# Outer Dowsing Offshore Wind

## The Applicant's Change Notification dated 13 December 2024

Date: December 2024  
Document Reference: 20.18  
Rev: 1.0

**Planning Act 2008 – Application for Development Consent  
GT R4 Limited, trading as Outer Dowsing Offshore Wind (the “Applicant”)  
The Proposed Outer Dowsing Offshore Wind Farm Order  
Change Notification  
Application Reference: EN010130**

Environmental Statement  
 Displacement Buffers from the ORCPs  
 Figure 12.2

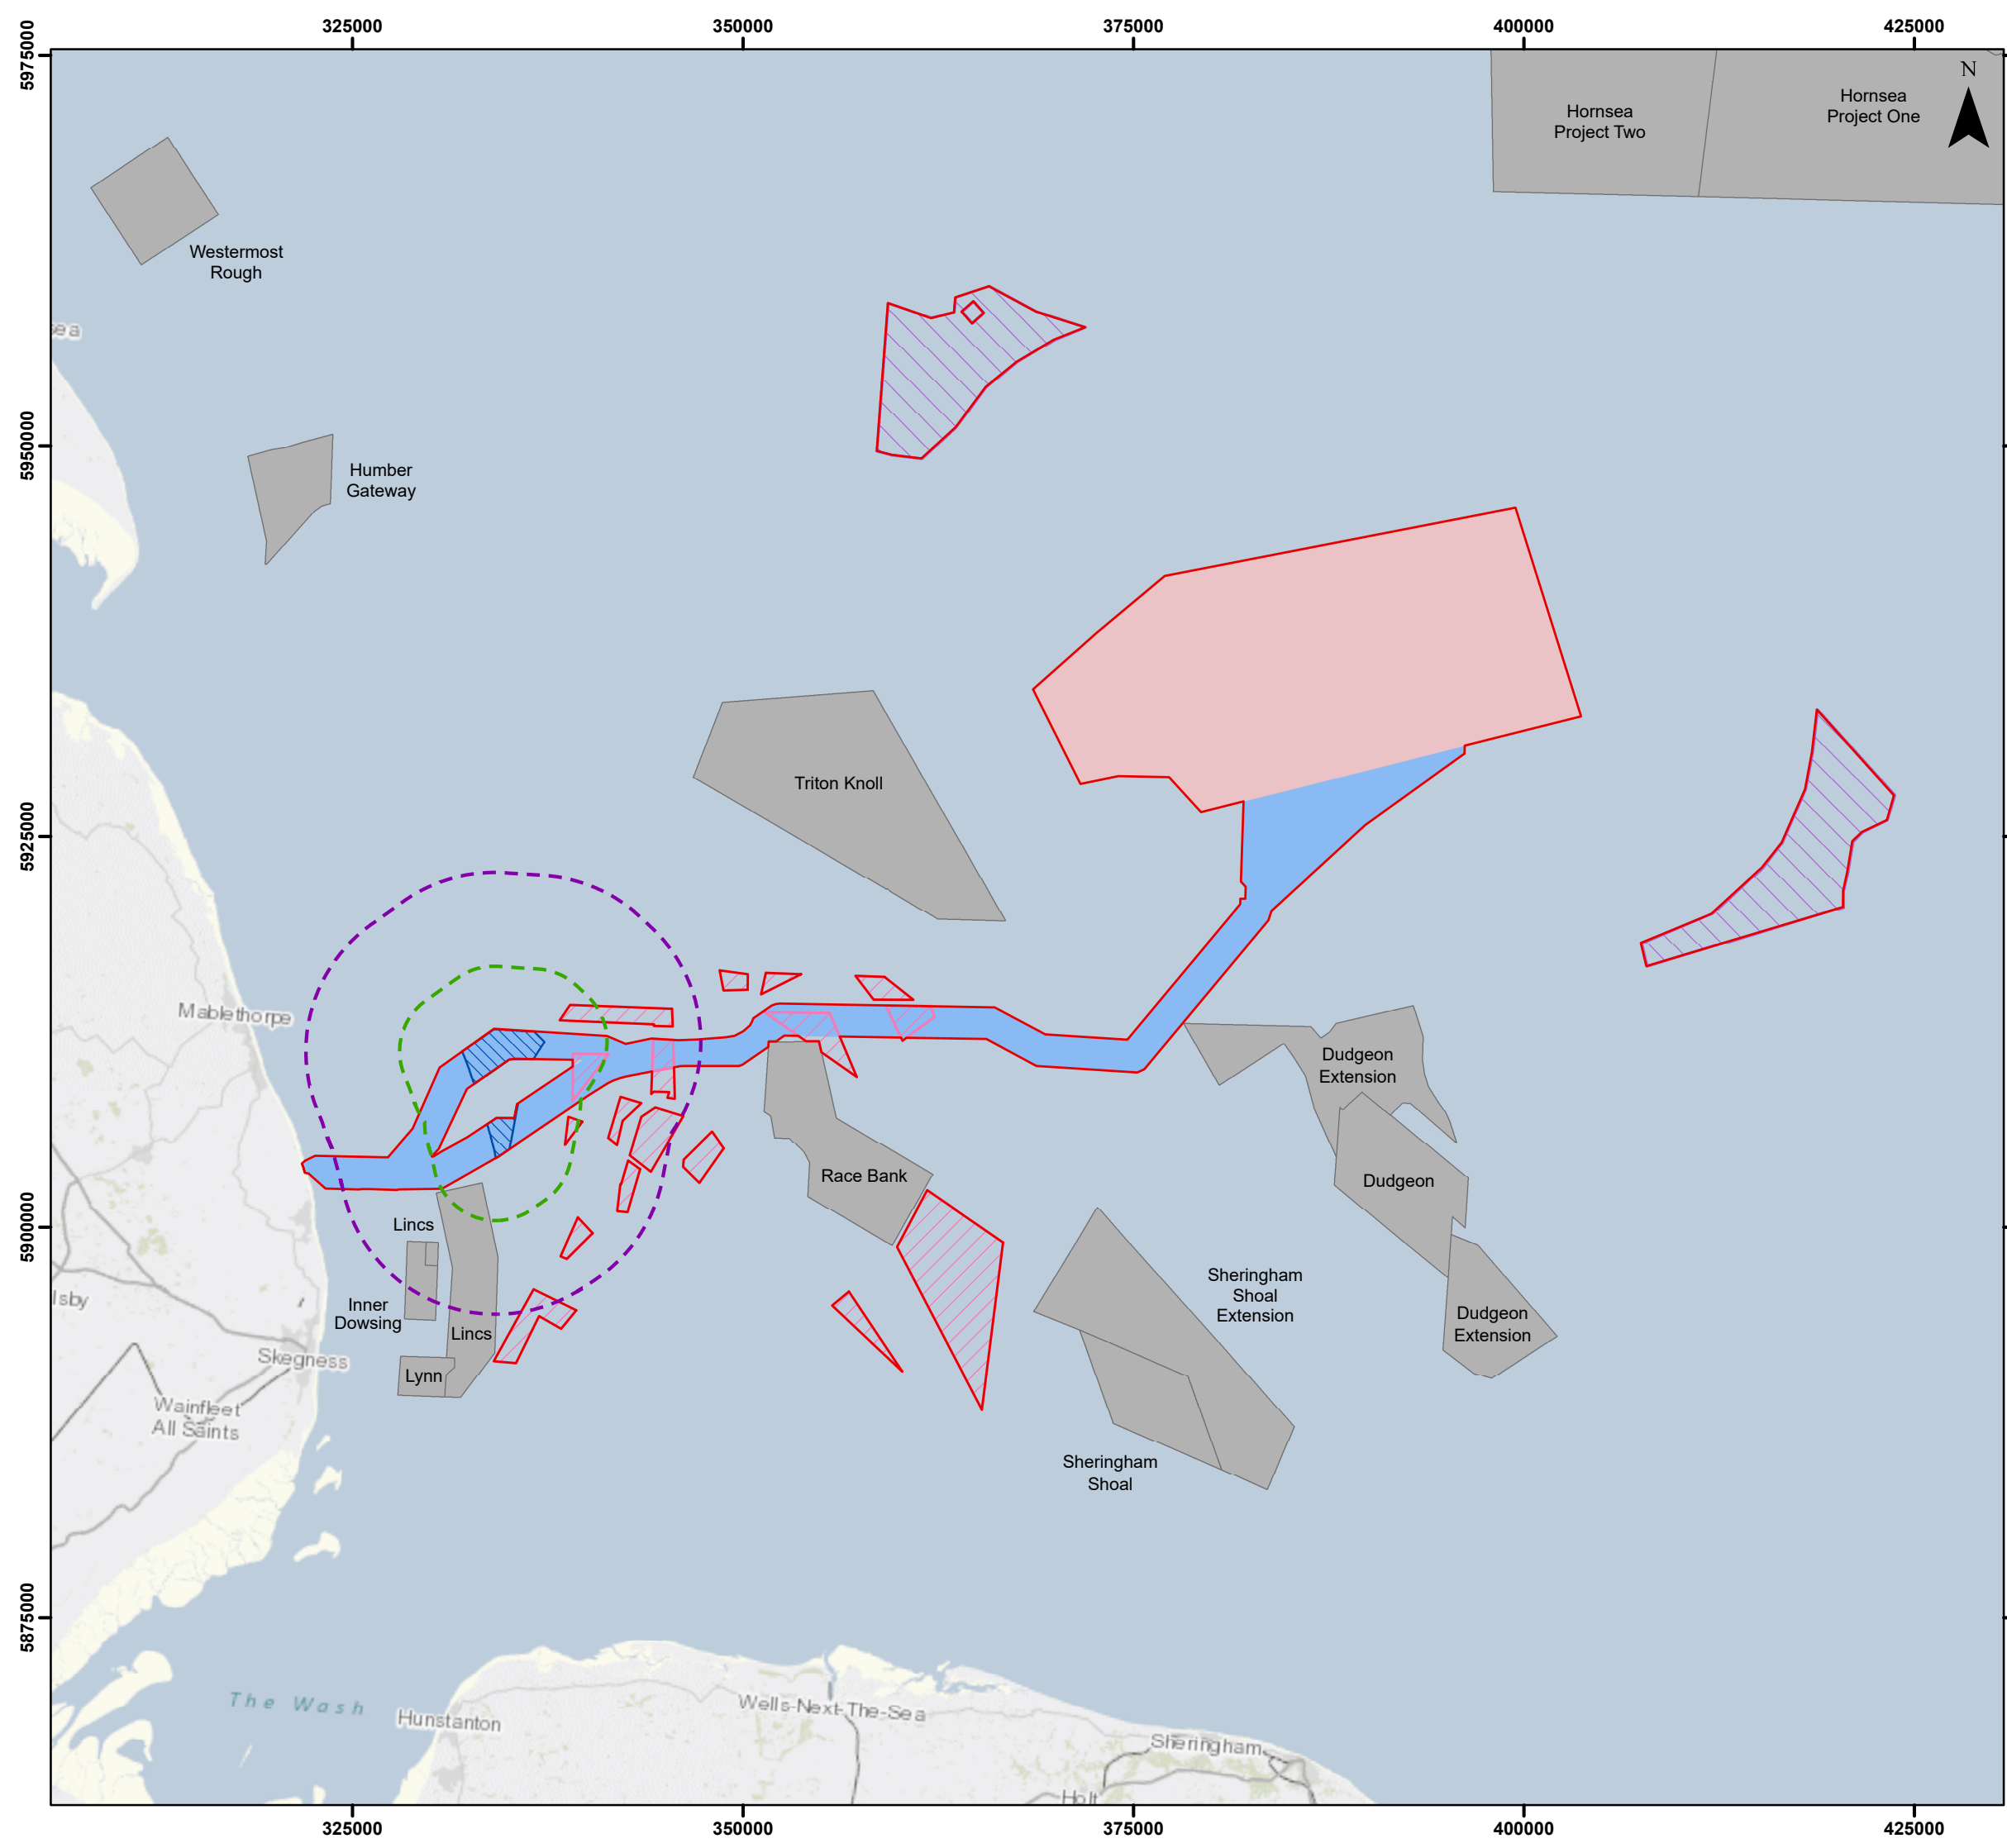
The Applicant’s review is progressing and the Applicant is now in a position to confirm a change to the Application to reduce the Maximum Design Parameters of the ORCPs, including a reduction in the height of the ORCPs to 59.2m above lowest astronomical tide (LAT), with any mast or antenna located on the ORCPs to be a maximum height of 79.2m above LAT.
